WEST SUSSEX COUNTY COUNCIL CONSULTATION

TO:	Arun District Council FAO: Amber Willard
FROM:	WSCC - Highways Authority
DATE:	31 October 2019
LOCATION:	Bishop Tufnell C Of E Junior School Pennyfields Bognor Regis PO22 6BN
SUBJECT:	FP/197/19/PL Glazed corridor link between the Infant and Junior schools, extension to staffroom & internal alterations which combine the administration areas so the building functions as one school.
DATE OF SITE VISIT:	n/a
RECOMMENDATION:	Advice
S106 CONTRIBUTION TOTAL:	n/a

The proposed seeks a glazed corridor link between Bishop Tufnell Junior & Infant Schools, with an extension to the staffroom & internal alterations which combine the administration areas so the building functions as one school.

PROPOSED GROUND FLOOR PLAN

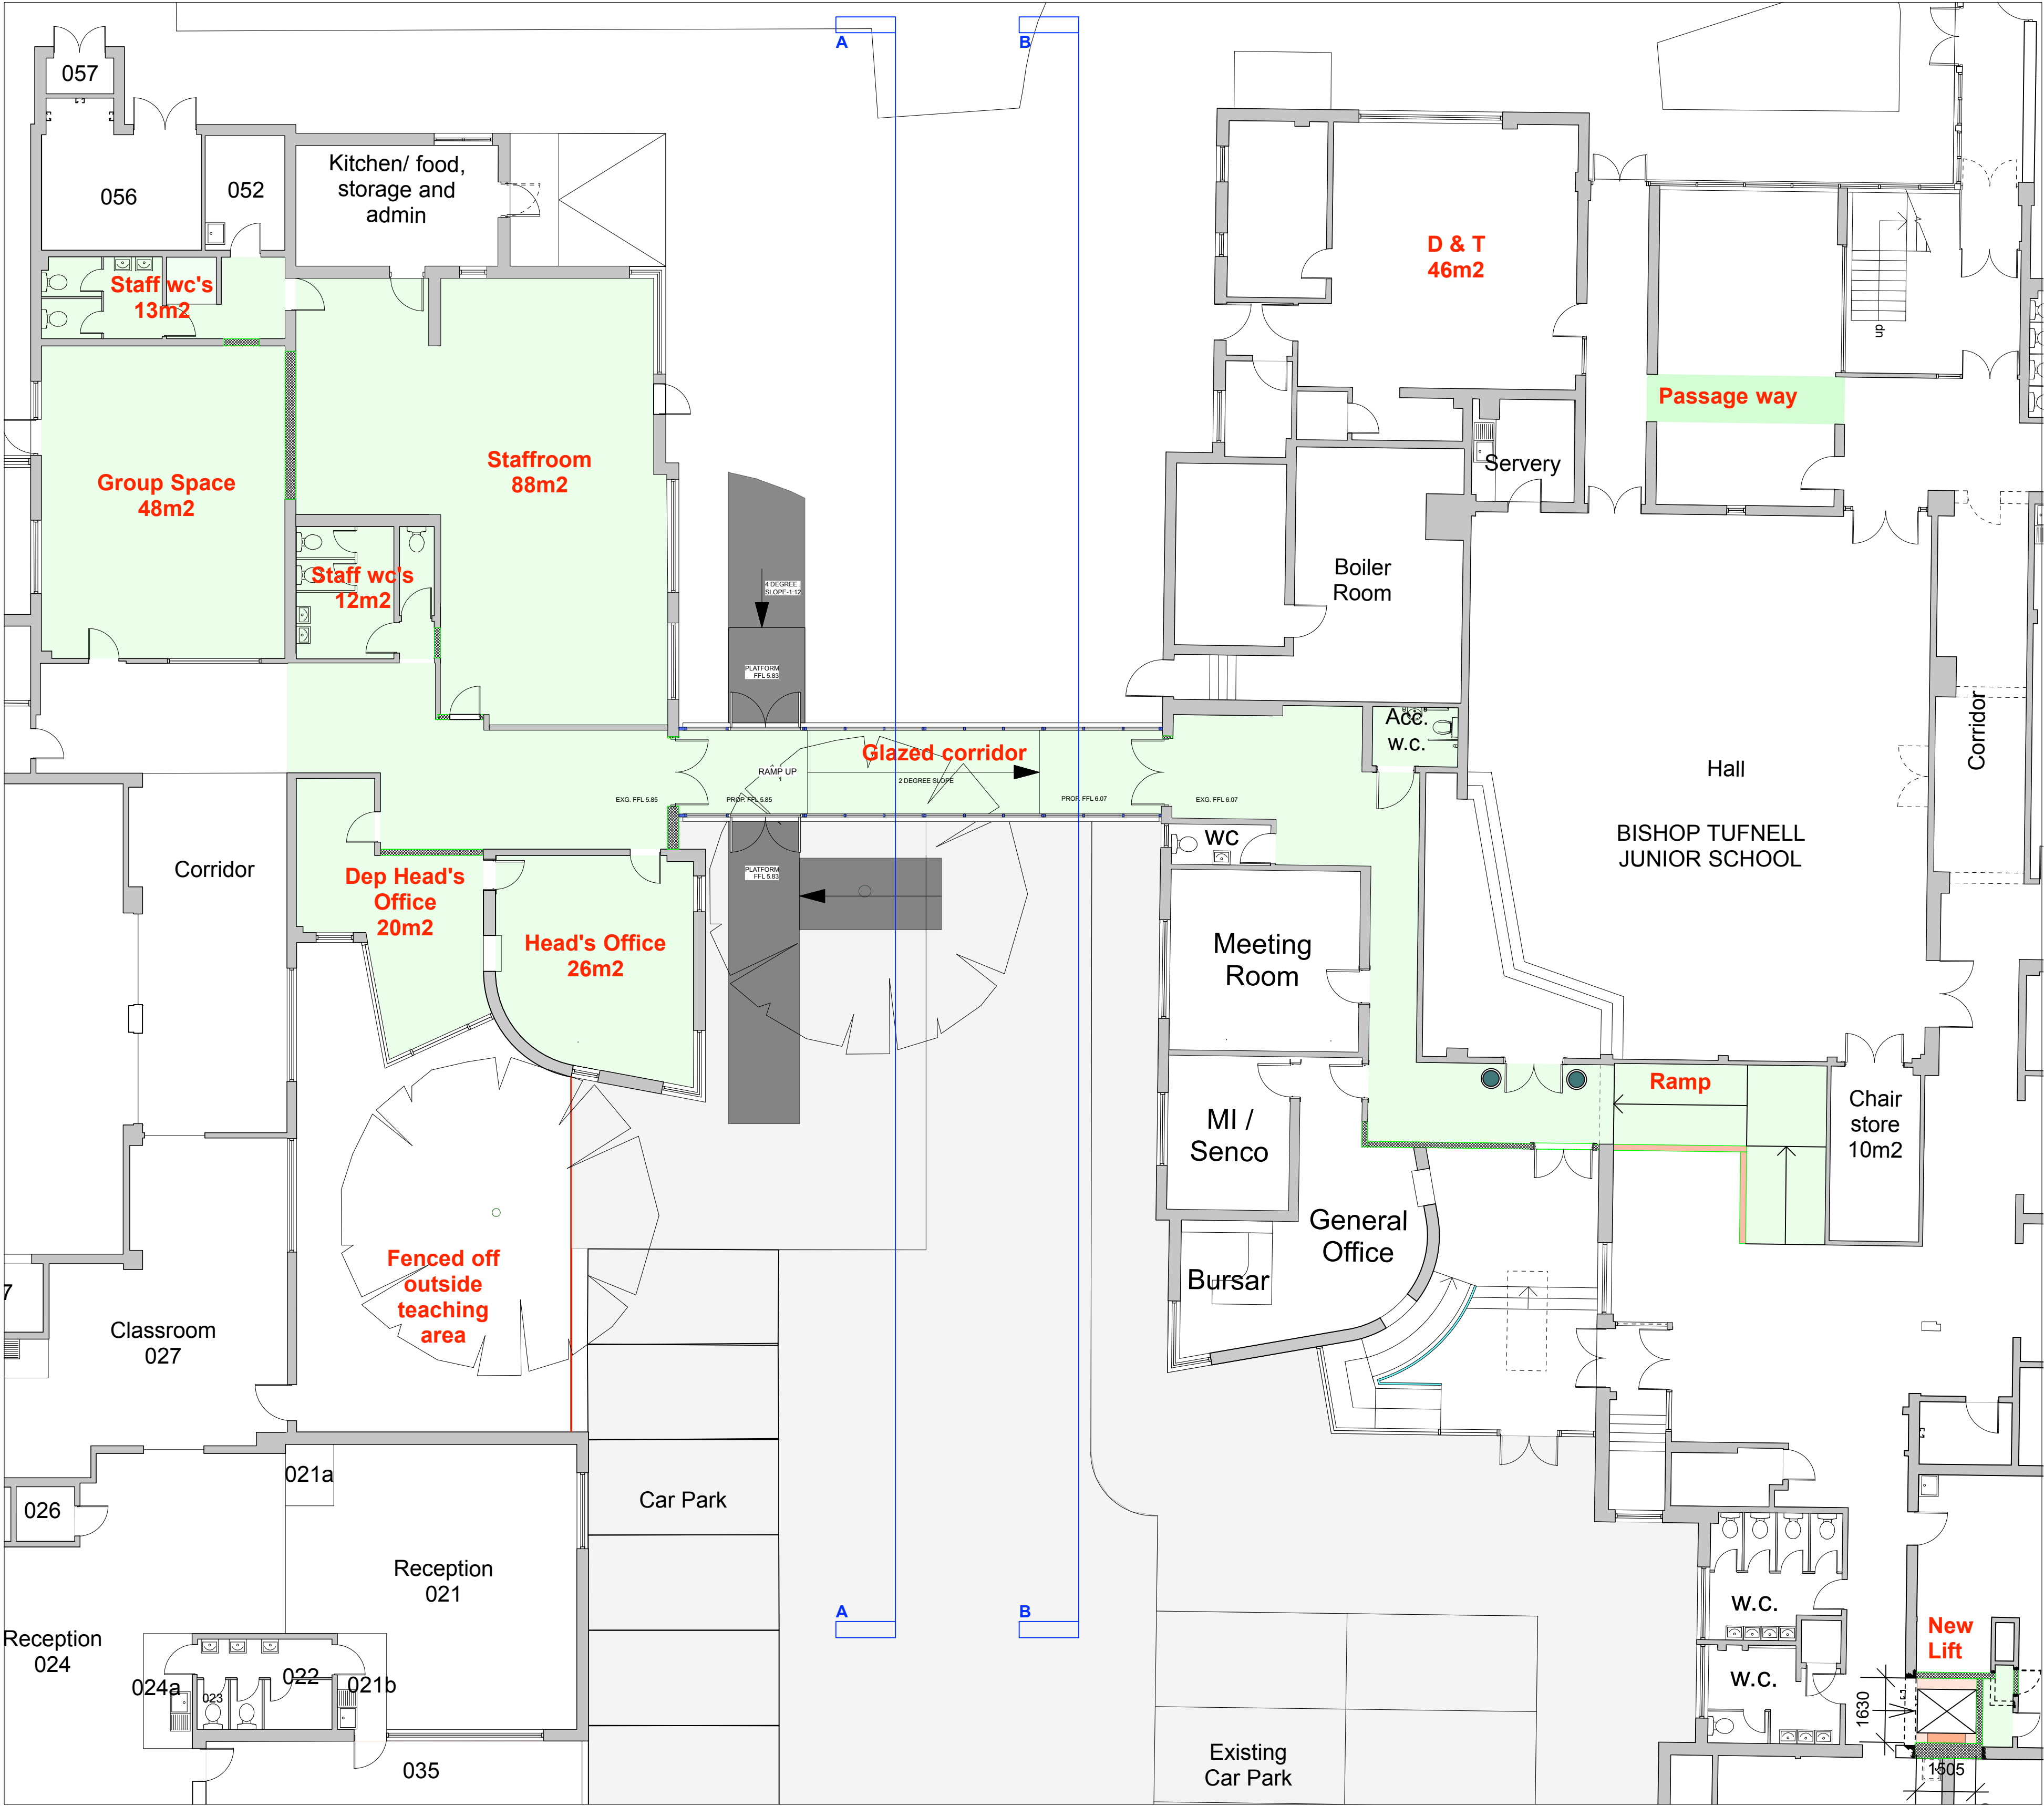
The works will impact upon some of the existing car parking spaces. It is proposed to create an additional 8 spaces as a result. From inspection of the proposed ground floor plan these spaces will be appropriately sized, accessible and given the opportunity to turn on site.

drawing: SITE PLAN AND BLOCK PLAN

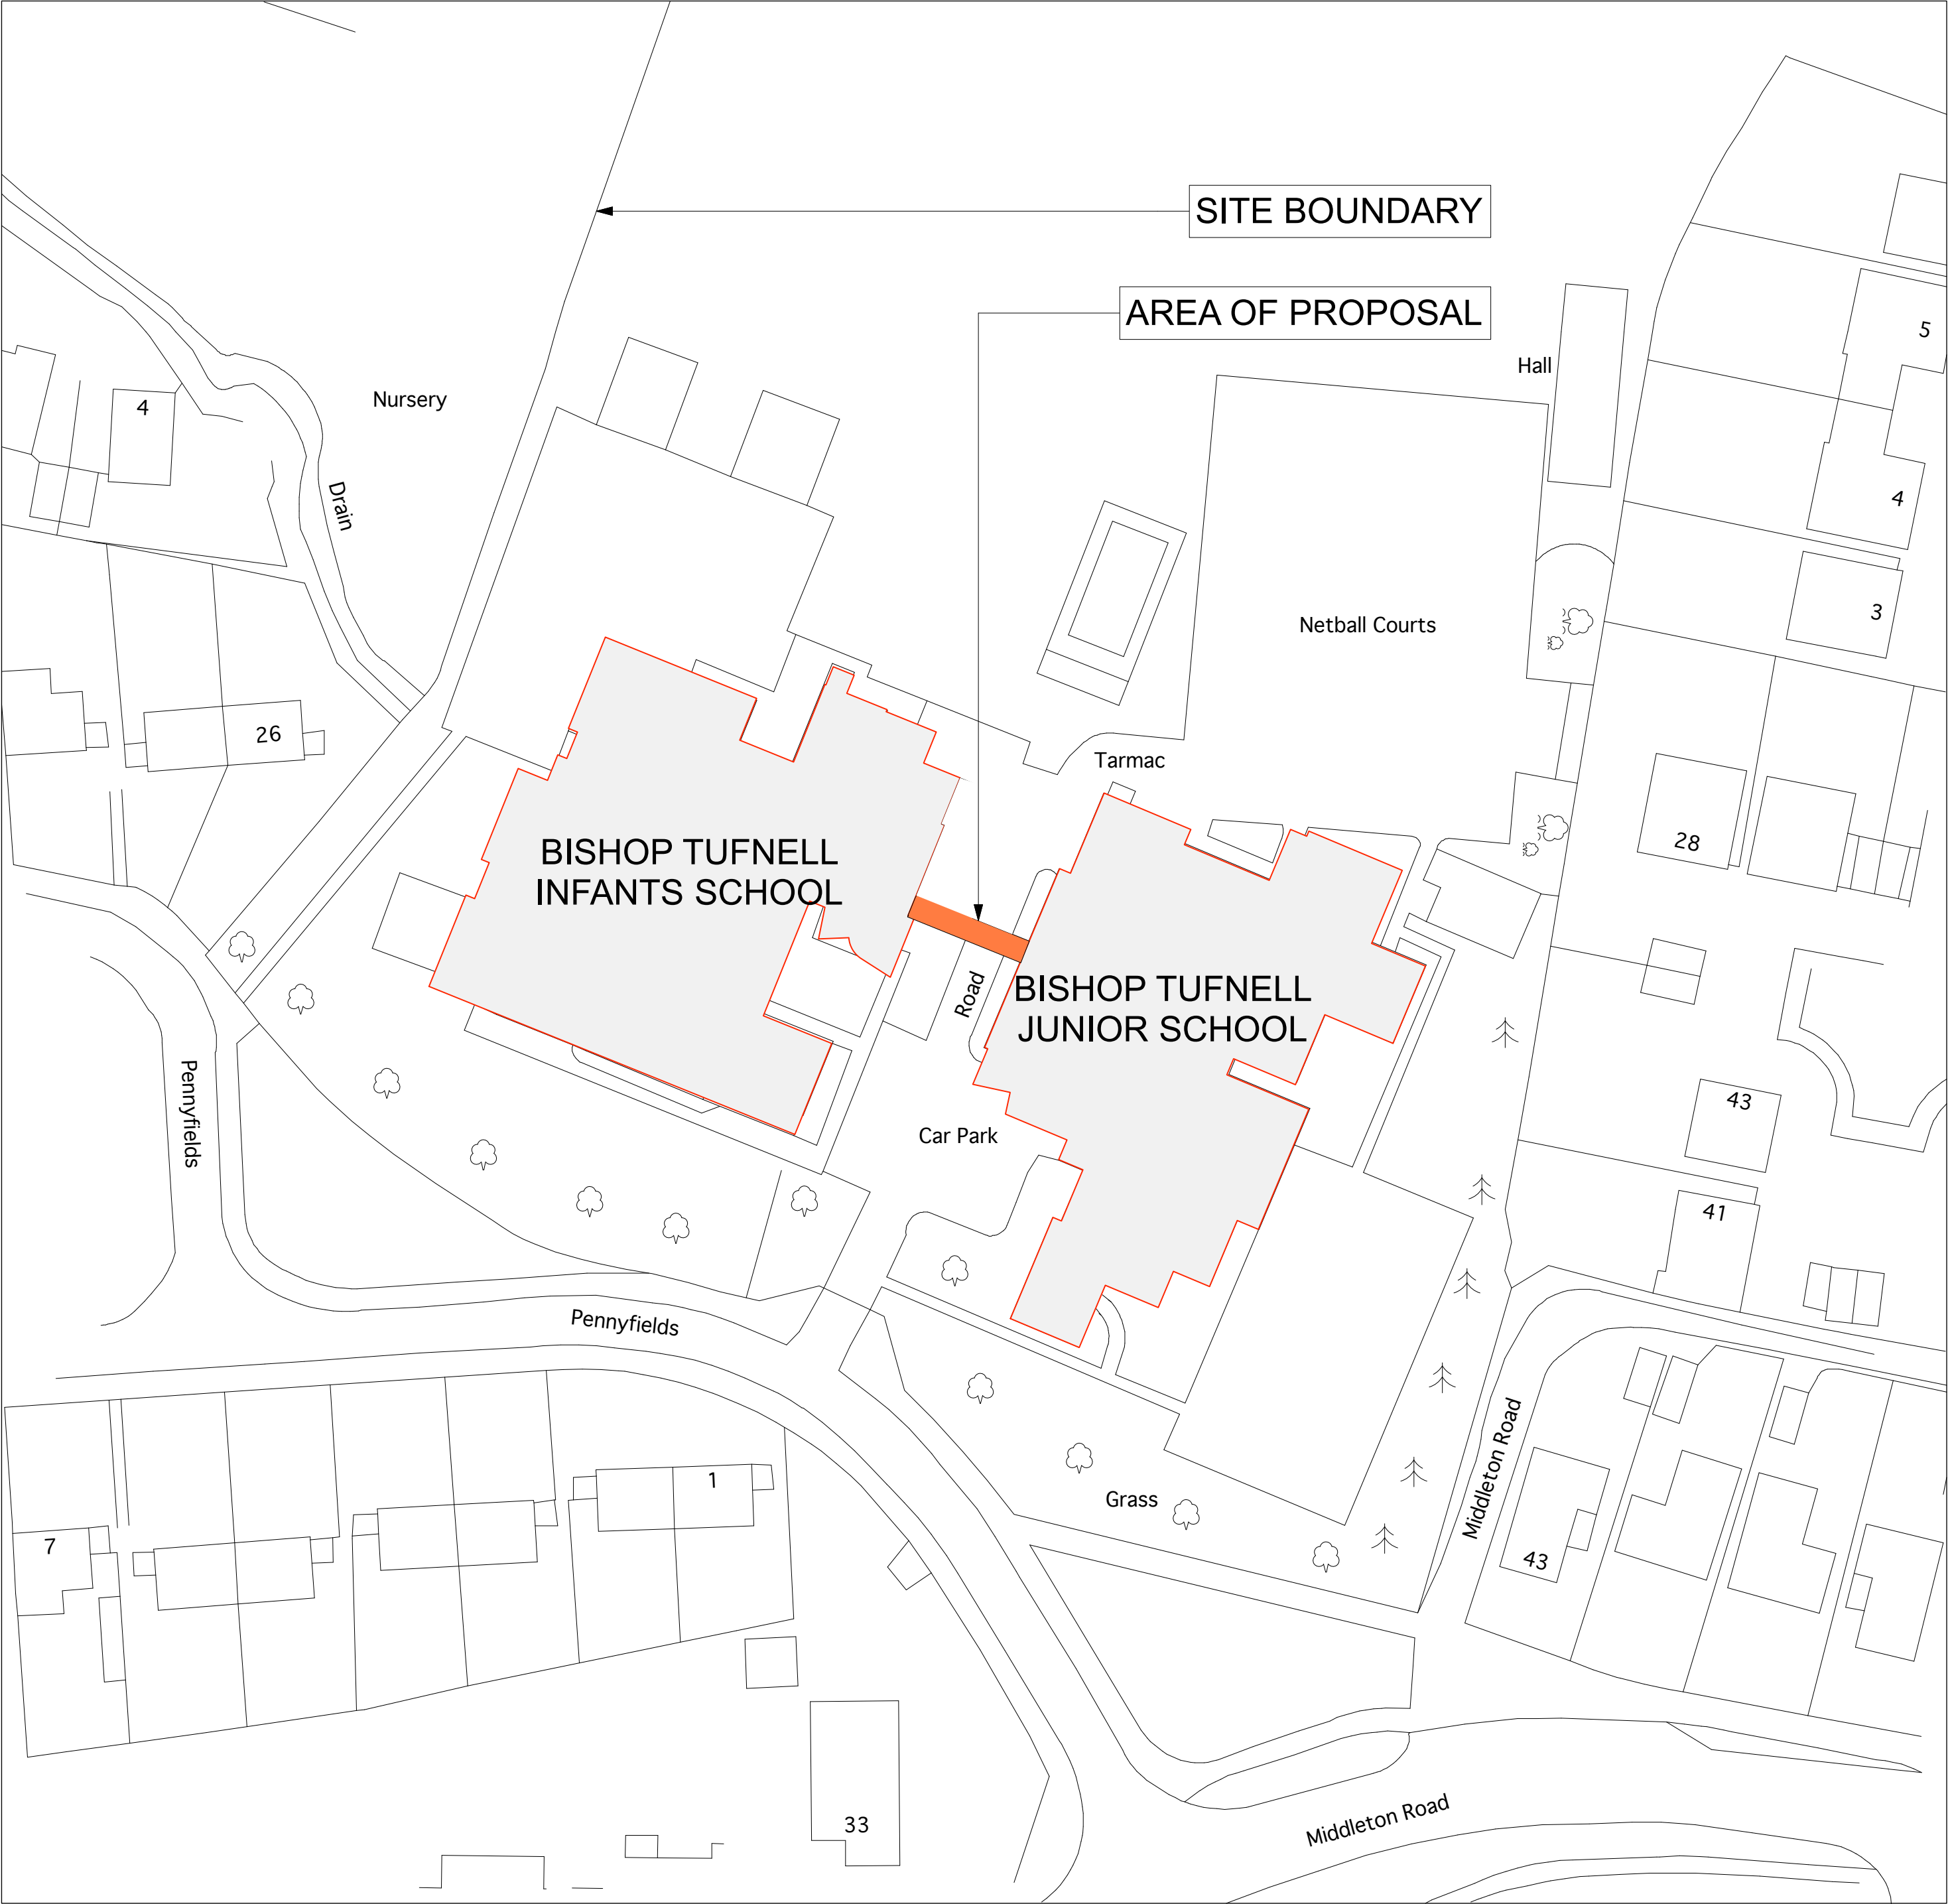
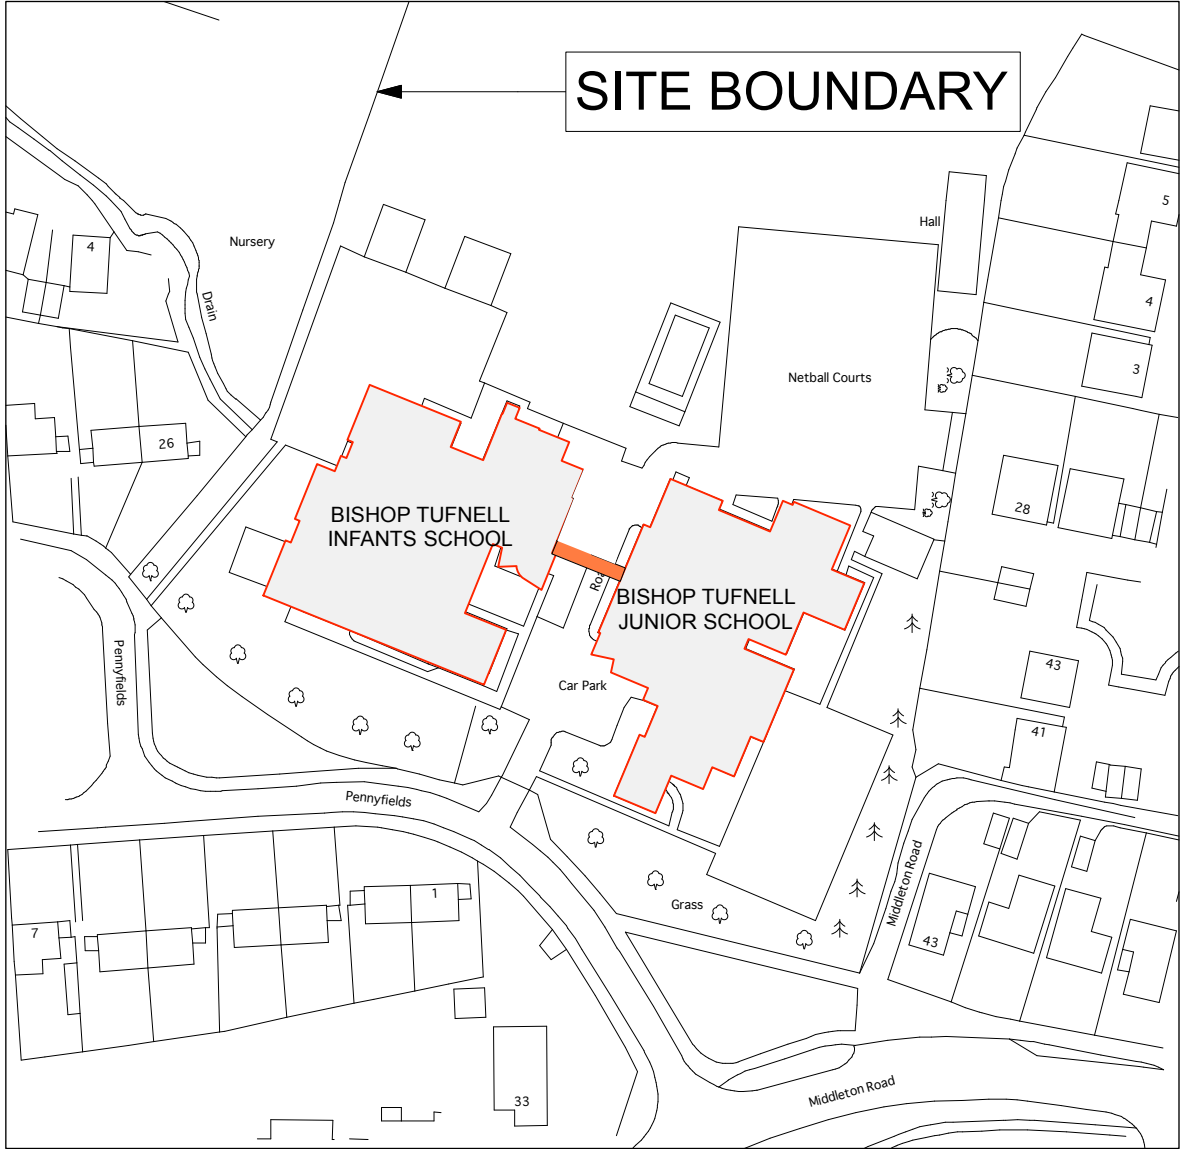
The visitor pedestrian access point east of the main vehicular access gate is to be slightly relocated to a point within the splayed main vehicular entrance. While this does not impact upon the public highway the applicants would be advised to replace the cobbled

area that connects this point to the maintained footway to ensure accessibility for all users.

A pupil pedestrian access point will be created on the southern boundary, at the eastern side of the site. Again the access works here do not impact upon the maintained highway, and there is some benefit in relocating these pedestrian movements away from the main vehicular access and residential property at the western extent of the site.

The existing pupil access point at the western extent of the site, via Pennyfields, will be replaced with an emergency / maintenance vehicle access point. Pennyfields is an unclassified cul-de-sac / no through road.

There are no highway concerns with vehicular visibility at this point. I would ask that the boundary hedging for 2 metres either side of the access point (and 2 metres within the site), is replaced with railings or similar to ensure maximum pedestrian visibility is provided at this point.

The access will need to be provided with a dropped crossing which must be implemented to under licence to a specification obtained from WSCC Highways. This will also require the removal of the pedestrian guard railing in this location.

Specific details of any crossover works here have not been demonstrated, these will need to be provided and secured via planning condition. I have suggested a condition below to secure these details though the applicant may wish to agree the specifics of the crossover (location and width) prior to determination.

The use of the emergency / maintenance access point shall not commence until such time as the access has been constructed in accordance with plans and details to be submitted to and approved in writing by the Local Planning Authority.

No part of the development shall be first occupied until pedestrian visibility splays of 2 metres by 2 metres have been provided either side of the proposed site vehicular access onto Pennyfields in accordance with plans and details to be submitted to and approved in writing by the Local Planning Authority. These visibility splays shall thereafter be kept free of all obstructions over a height of 0.6 metre above adjoining carriageway level or as otherwise agreed.
